RE: Project 1000270; 14EPC-40024

The purpose of this letter is to explain how we have addressed the Environmental Planning Commission's (EPC) Conditions of Approval for Project 1000270; 14EPC-40024, a Site Development Plan for Subdivision that was approved on May 8, 2014 by the EPC.

SITE PLAN FOR SUBDIVISION CONDITIONS OF APPROVAL

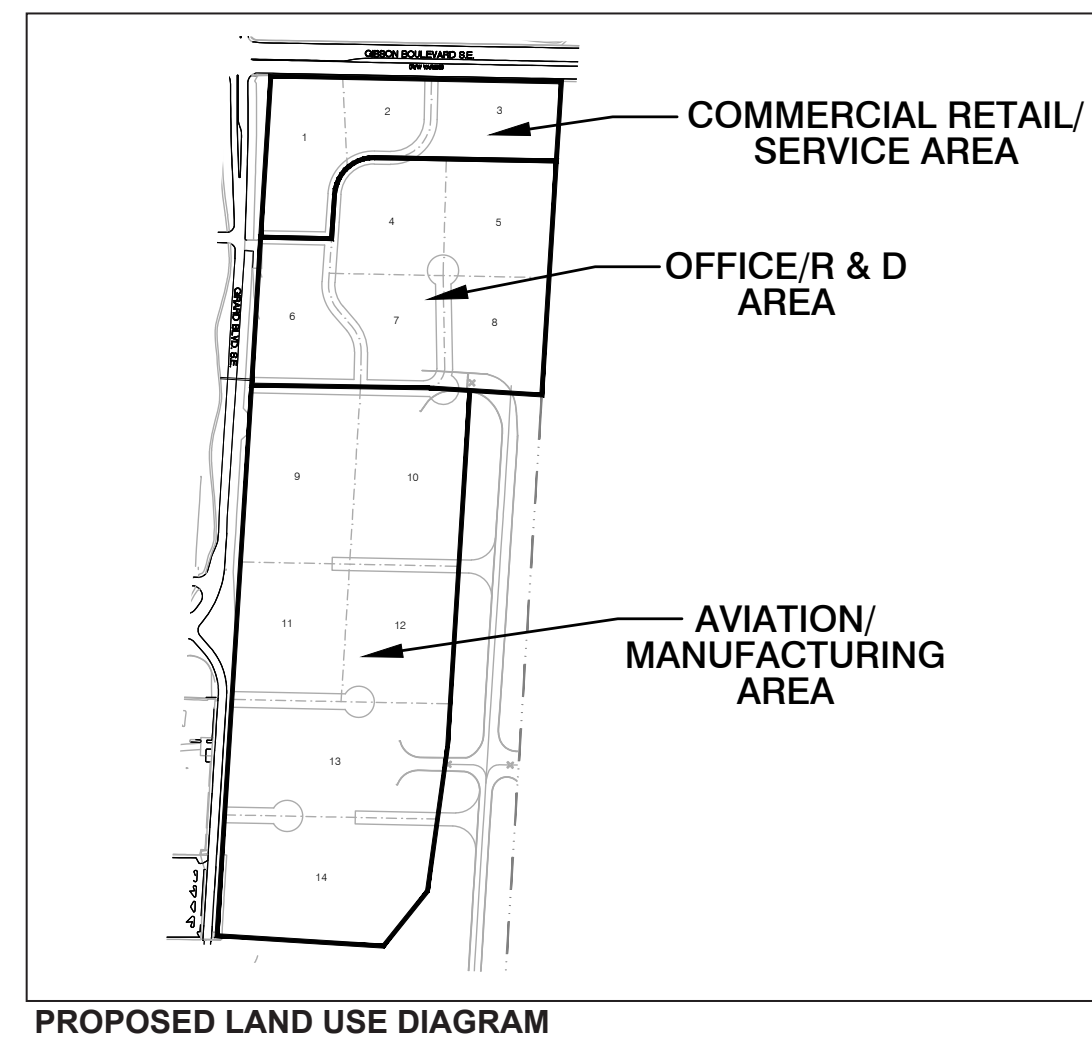
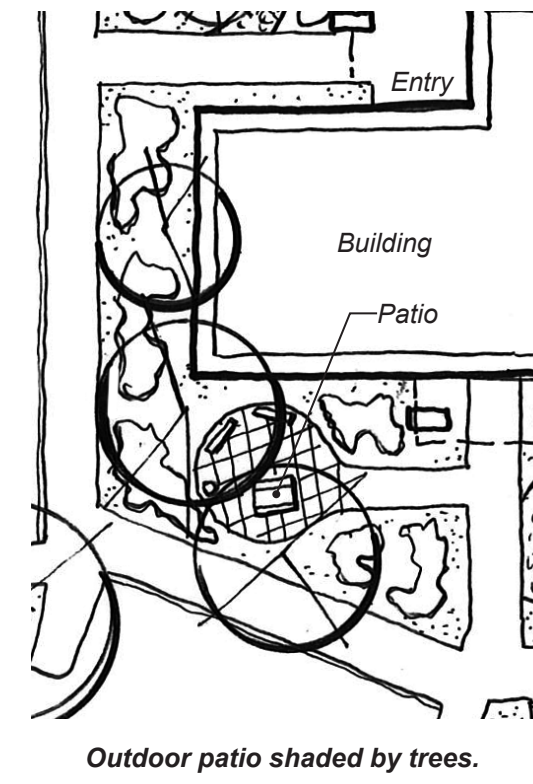
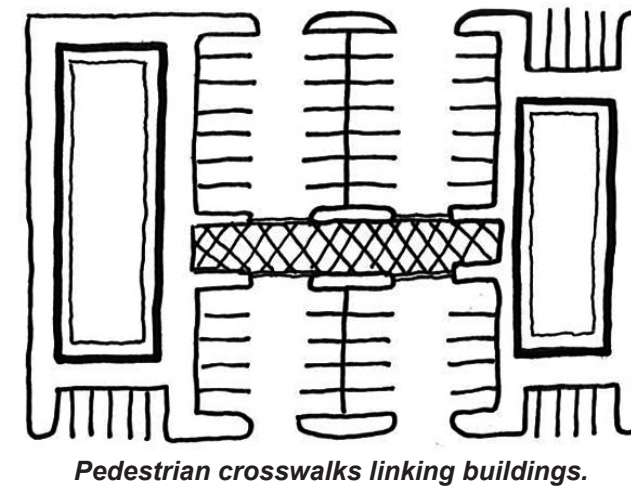
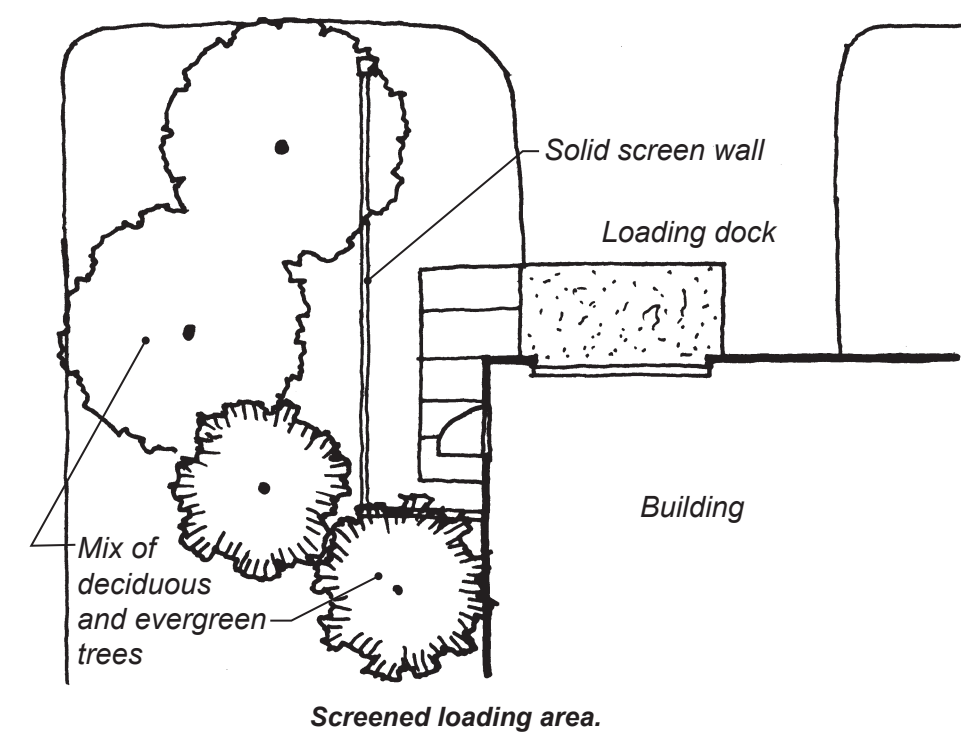
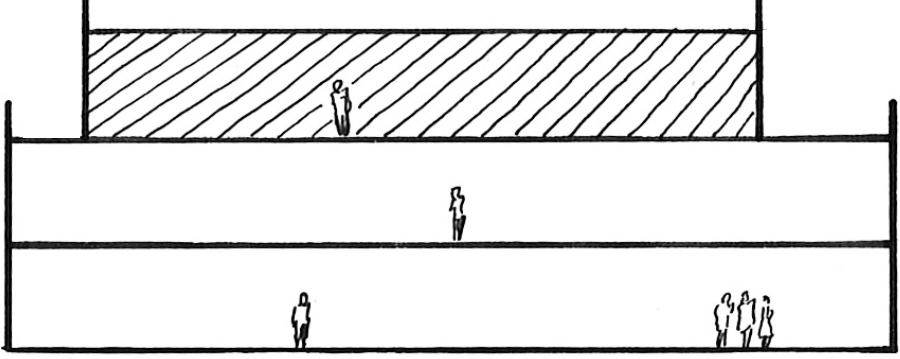
- a. On Sheet 2 of 5, Design Guidelines, add the following as a new item 6) to Section C, Screening & Walls/Fences:

Design ground-mounted equipment screening to allow for access to utility facilities. All screening and vegetation surrounding ground-mounted transformers and utility pads are to allow 10 feet of clearance in front of the equipment door and 5-6 feet of clearance on the remaining three sides for safe operation, maintenance and repair purposes. Refer to the PNM Electric Service Guide at www.pnm.com for specifications.

The Site Plan for Subdivision has been revised accordingly.
